RE: REVISED DRAINAGE PLAN FOR PHILLIPS 66 @ HANOVER & COORS (J11-D30)  
REVISION DATED 3/30/98

RE: CONCEPTUAL GRADING & DRAINAGE PLAN FOR PHILLIPS 66 @ HANOVER  
& COORS (J11-D30) ENGINEER'S STAMP DATED 10/23/97

**Re: Phillips 66 Hanover and Coors(J11-D30) Grading and Drainage Plan for Building Permit**

RE: REVISED DRAINAGE PLAN FOR PHILLIPS 66 - HANOVER & COORS (J11-D30)  
ENGINEER'S STAMP DATED 5/4/98

PHILLIPS 66 – HANOVER AND COORS
GRADING AND DRAINAGE PLAN

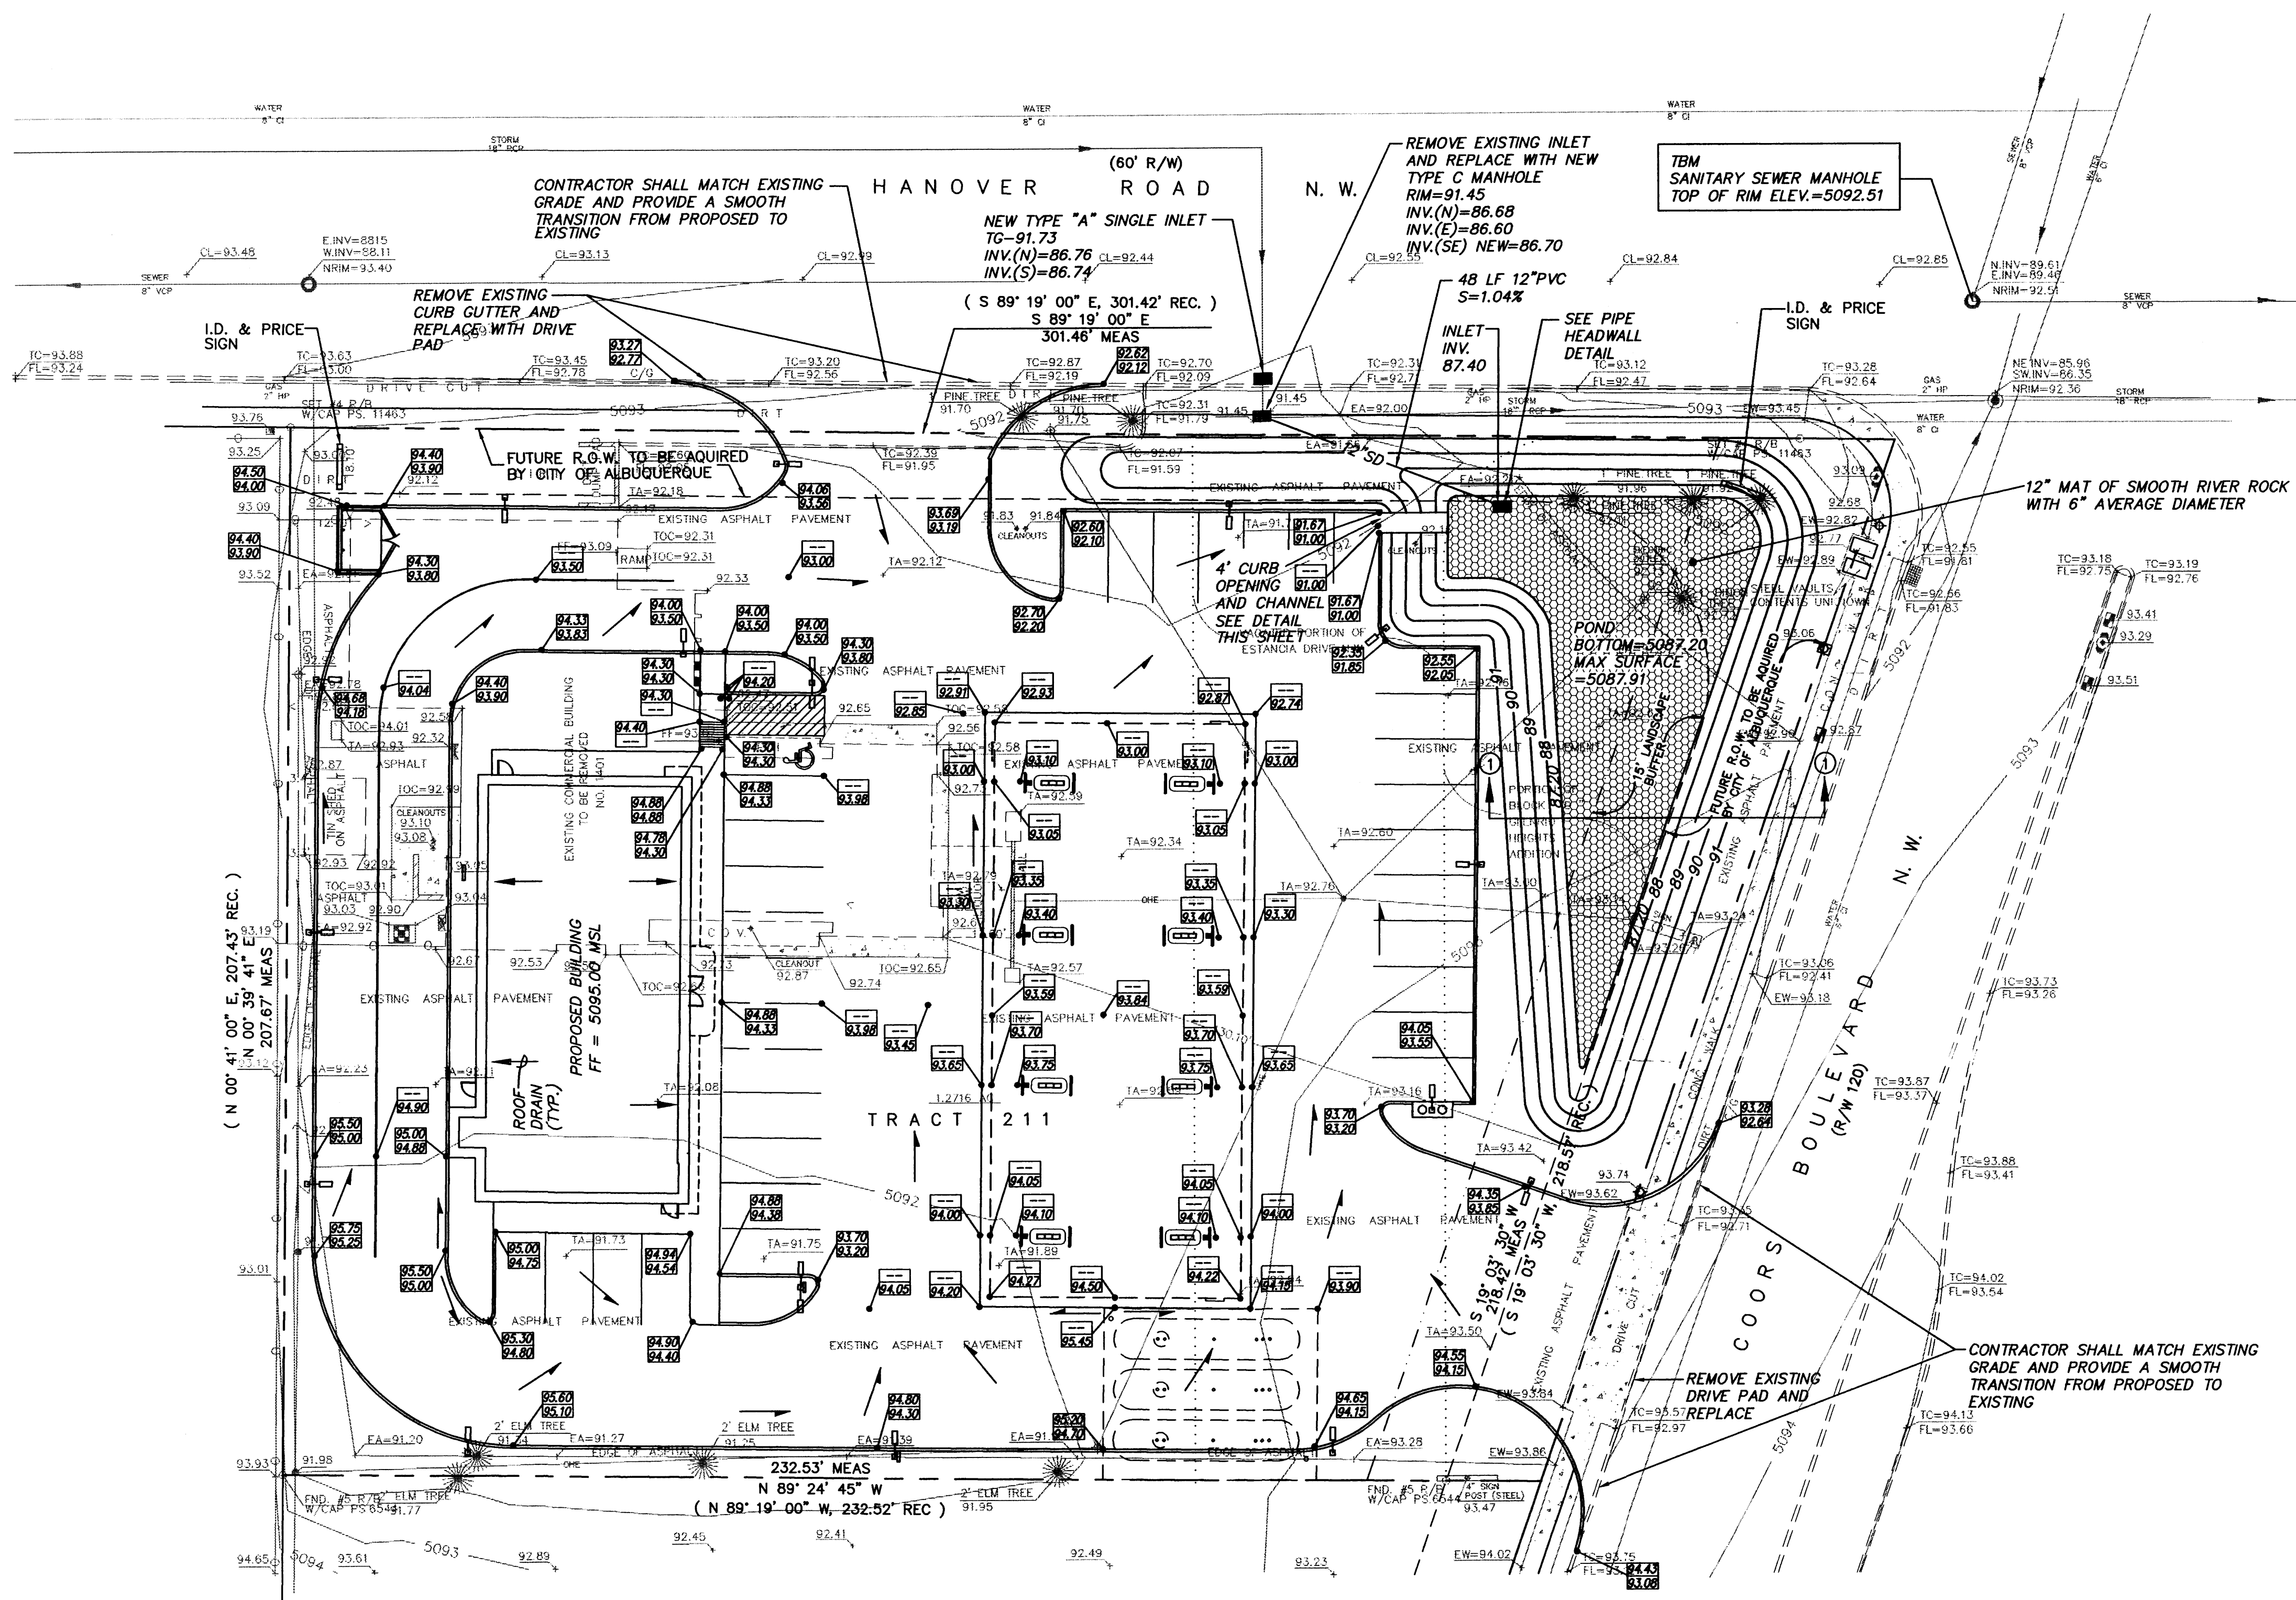
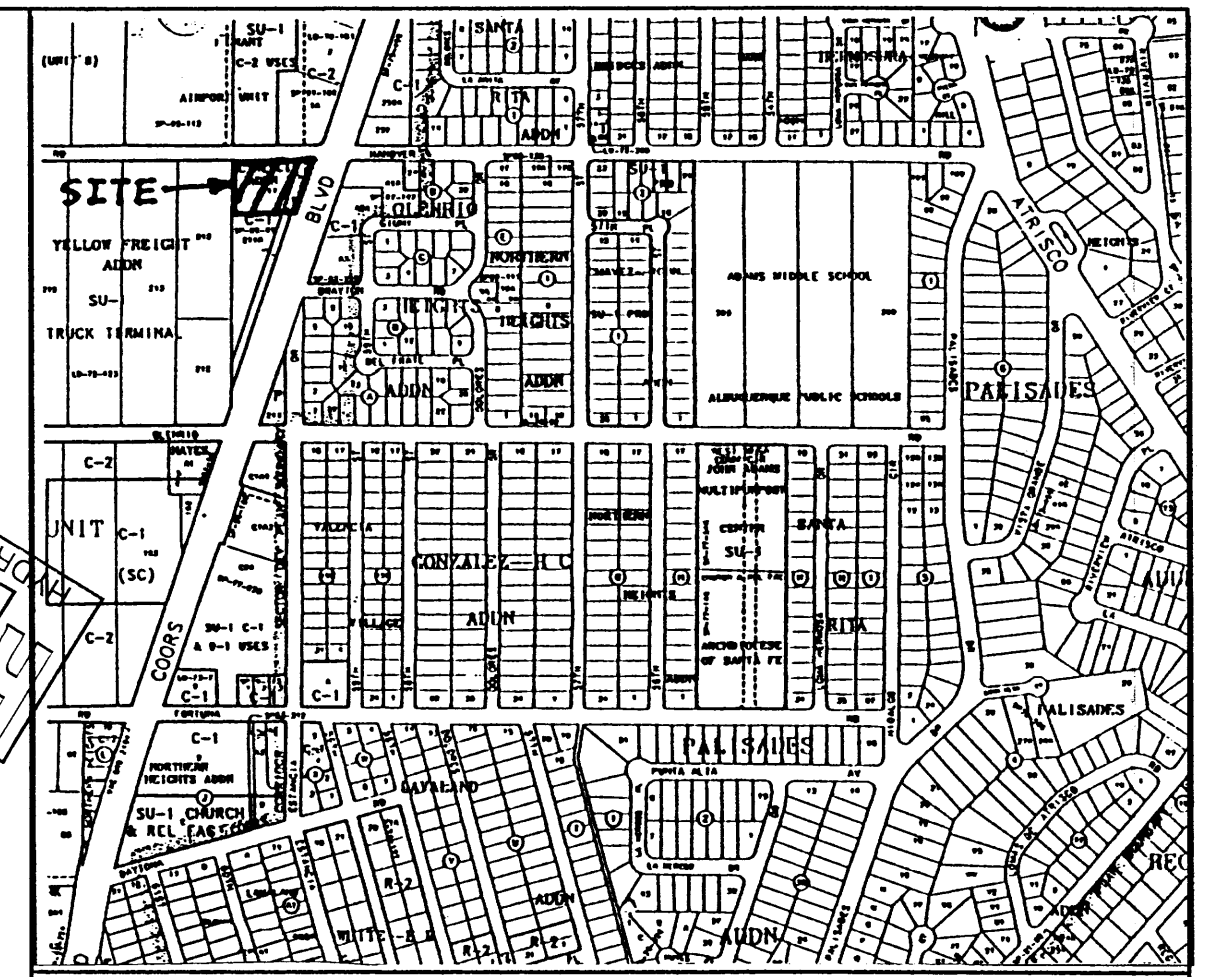
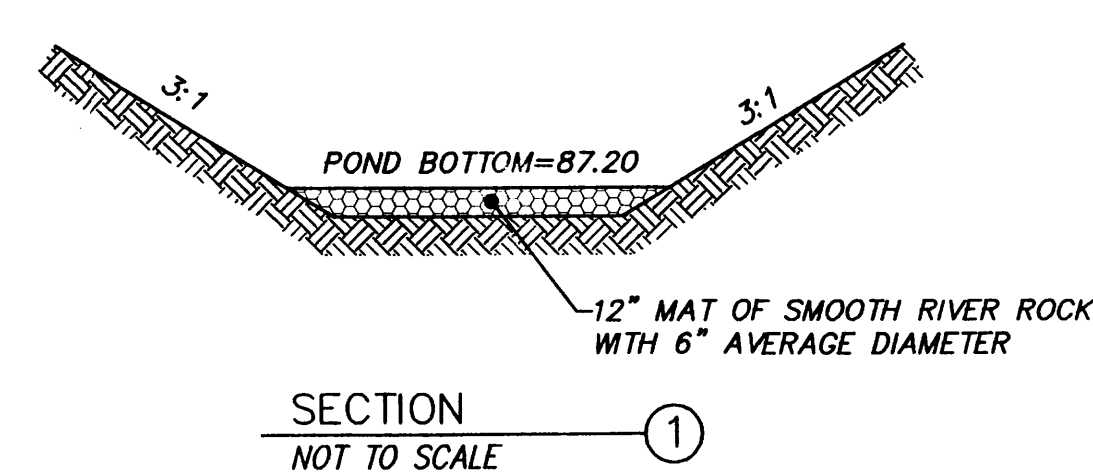
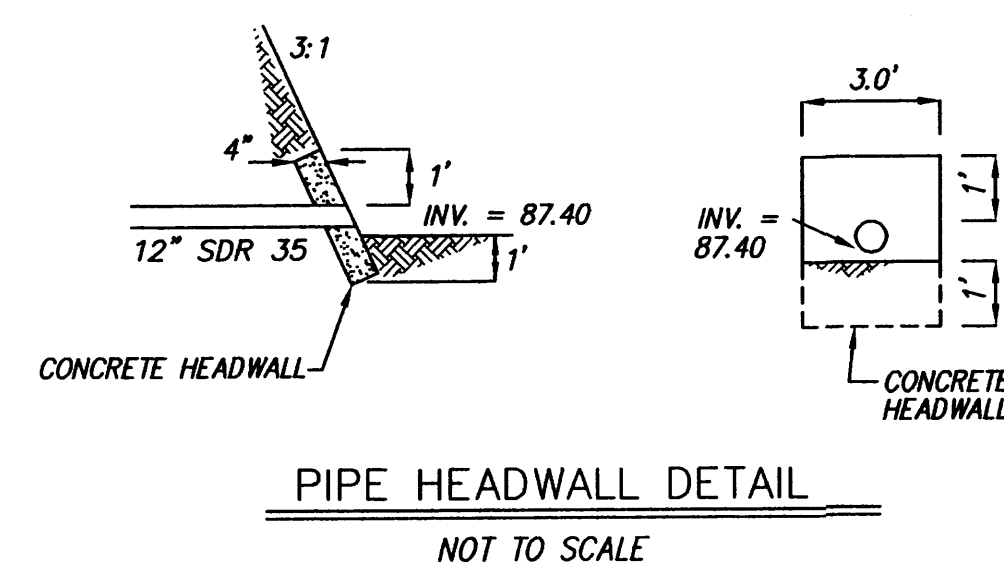
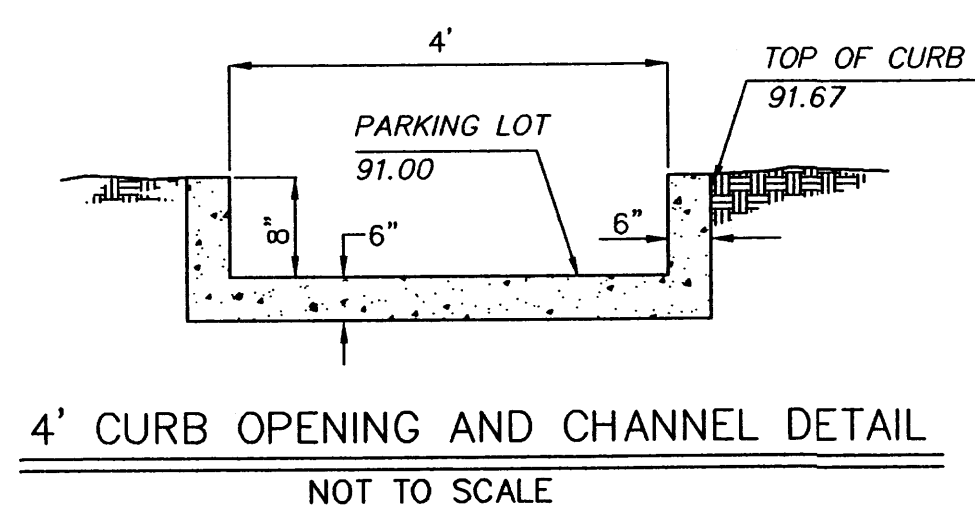
Must address R/W within the  
pending area

Verbal: 4/2/98 Address the  
addition R/W within the

The proposed site plan currently identifies a ponding area which would partially encroach into the future right of way. The consulting engineer for this site, has stated the sizing of the pond was based upon the maintaining the volume of flood plain within the site.

It is my understanding that at the time of implementation of the Coors Corridor improvements, storm drainage improvements will be included, thus minimizing the size of on-site ponding. I do not anticipate a major conflict with the potential encroachment of this pond onto future right of way and the proposed improvements for Coors Boulevard. The proposed corner radius for a channelized right-turn lane is the area which may be affected by the interim ponding area for an indefinite period until the proposed off-ramp for Interstate 40 is implemented.

- Comment #1- A copy of this revised plan has been submitted to Loren Meinz.
- Comment #2- The description as described on the drainage report was a mislabel.
- Comment #3- A 12" mat of smooth river rock has been added to the pond bottom for sediment control.
